Planning Department Transportation Development Services

**Re: Starbucks
700 Juan Tabo NE
30-Day Temporary Certificate of Occupancy- Transportation Development
Administrative Amendment dated 1-7-15 (K22-D006B)
Certification dated 9-23-15**

**RE: Starbucks Coffee Company
700 Juan Tabo NE, Albuquerque, NM
Traffic Conformance Letter**

SHEET TITLE:
SITE PLAN
SHEET NUMBER:
1 OF 7

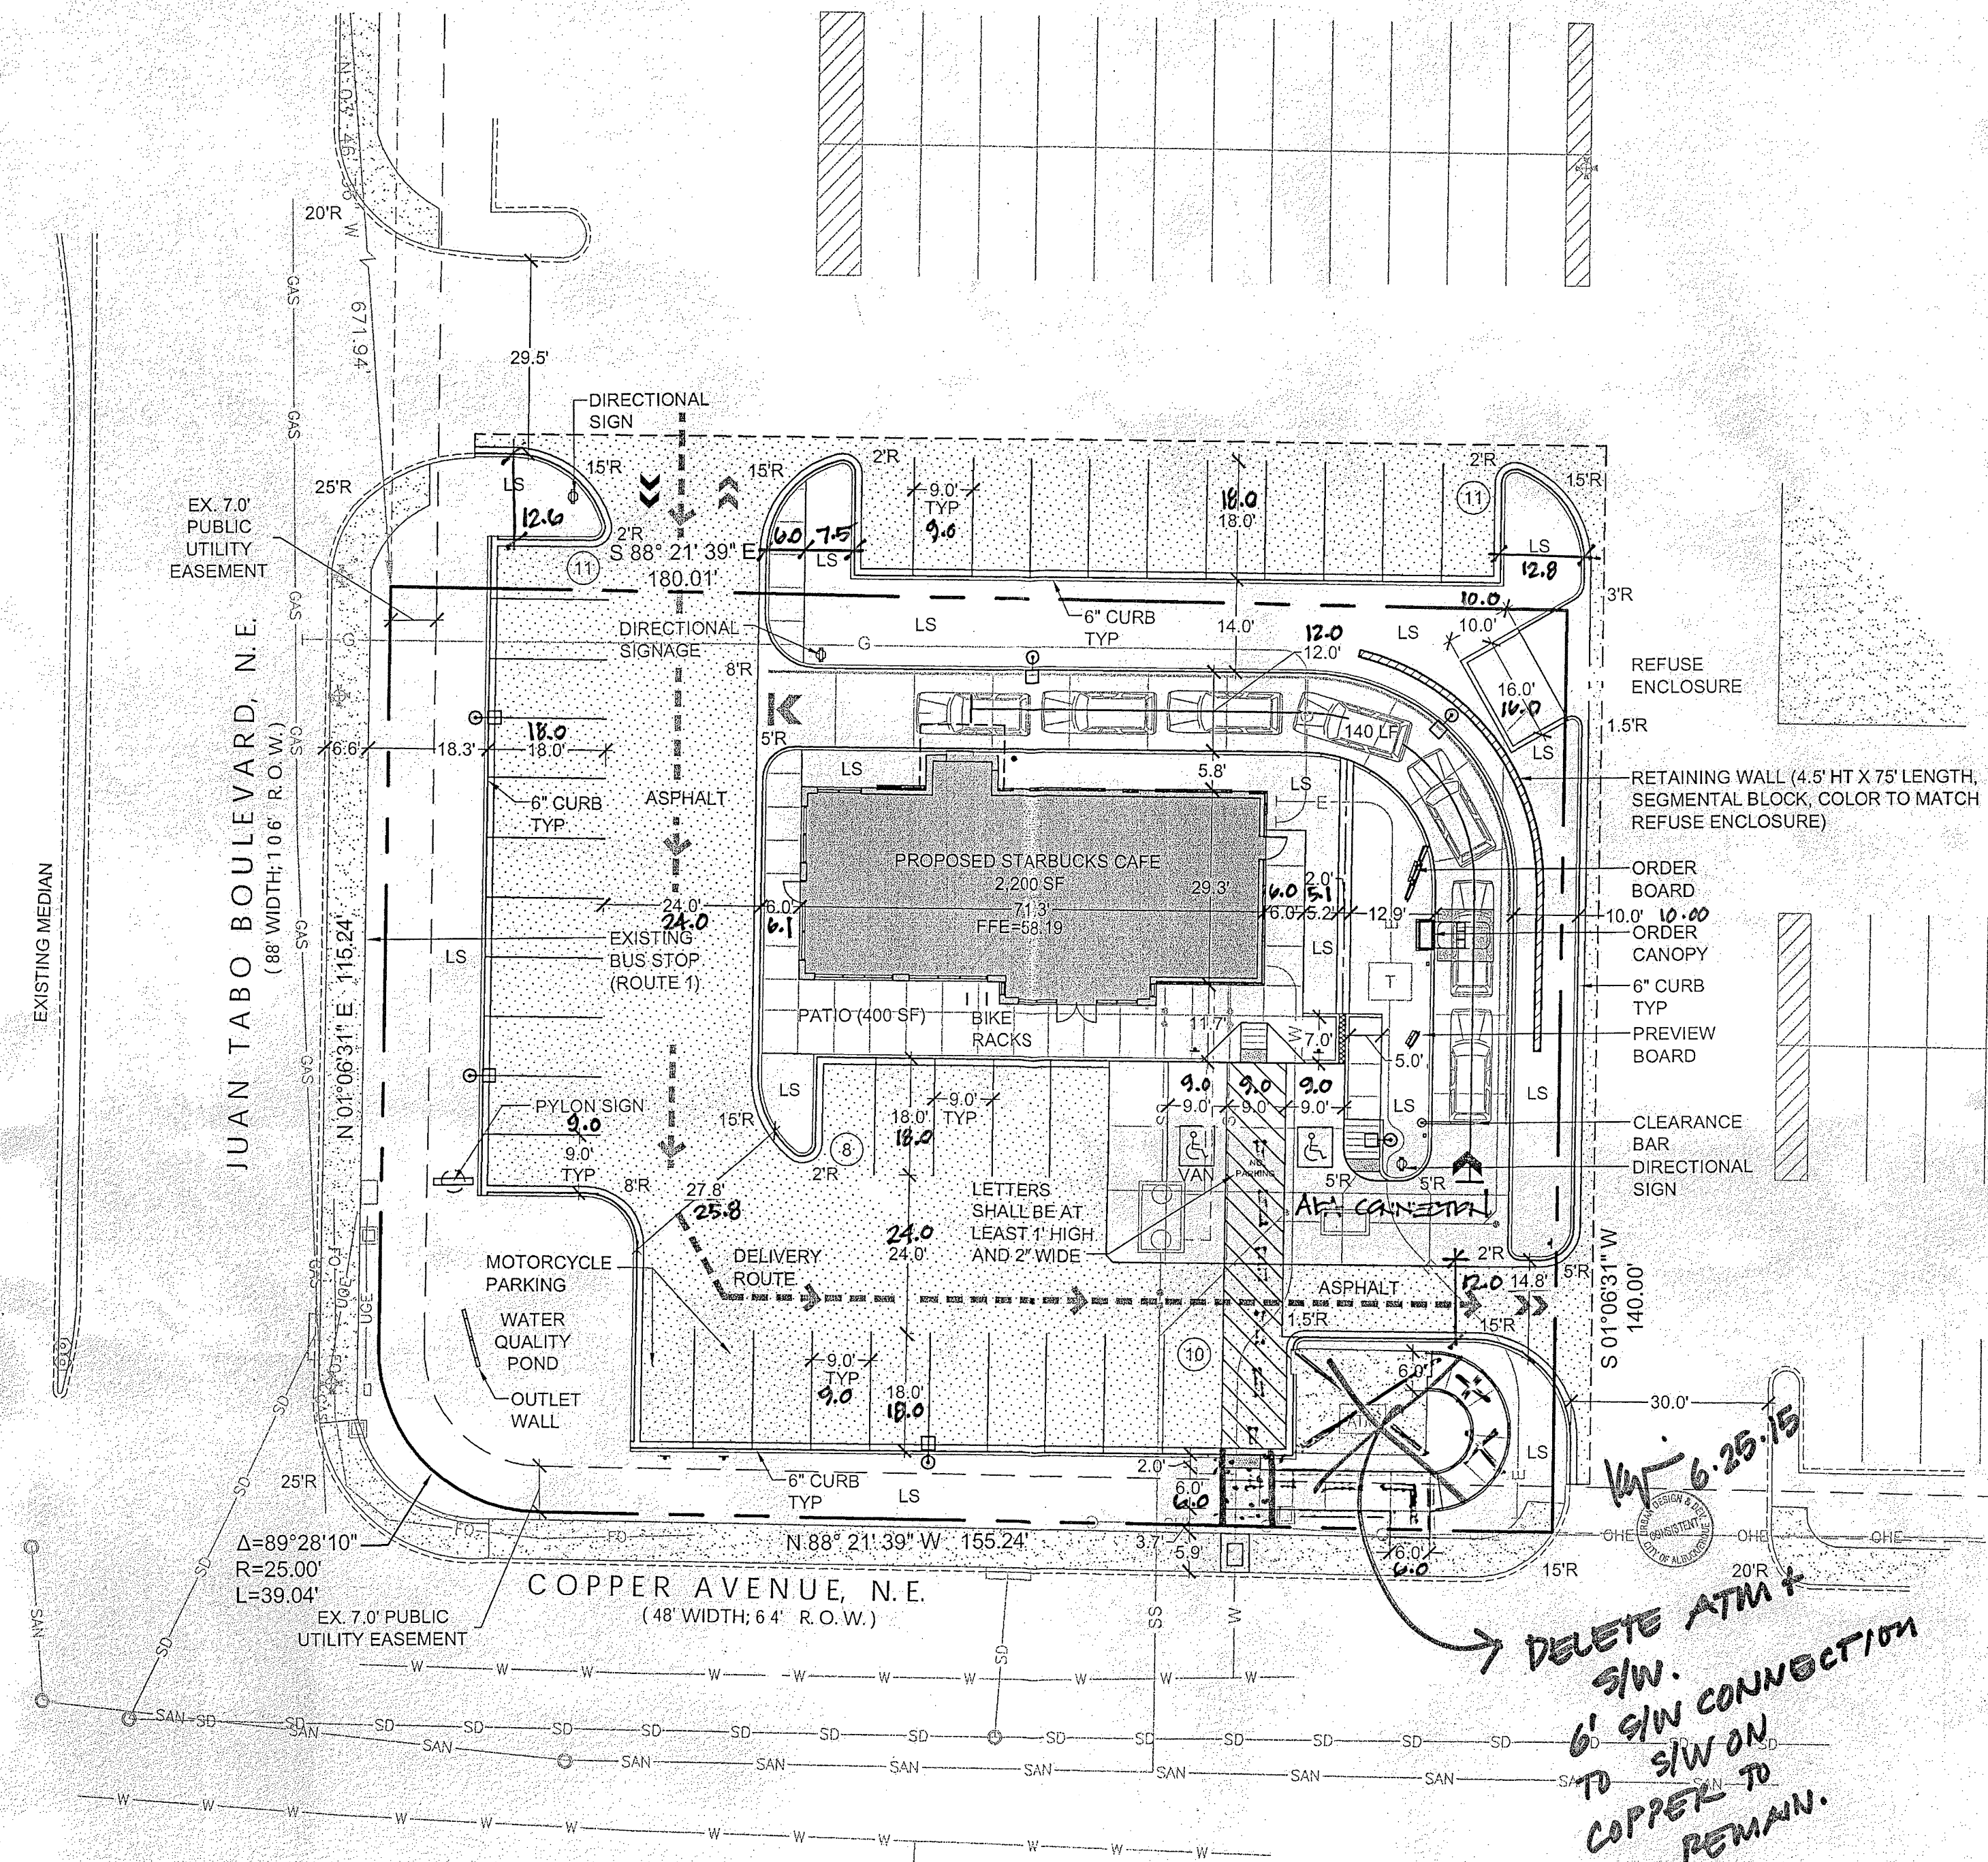
- Completion of ADA ramps and pathway from Right of Way on Copper Ave. to building entrance.
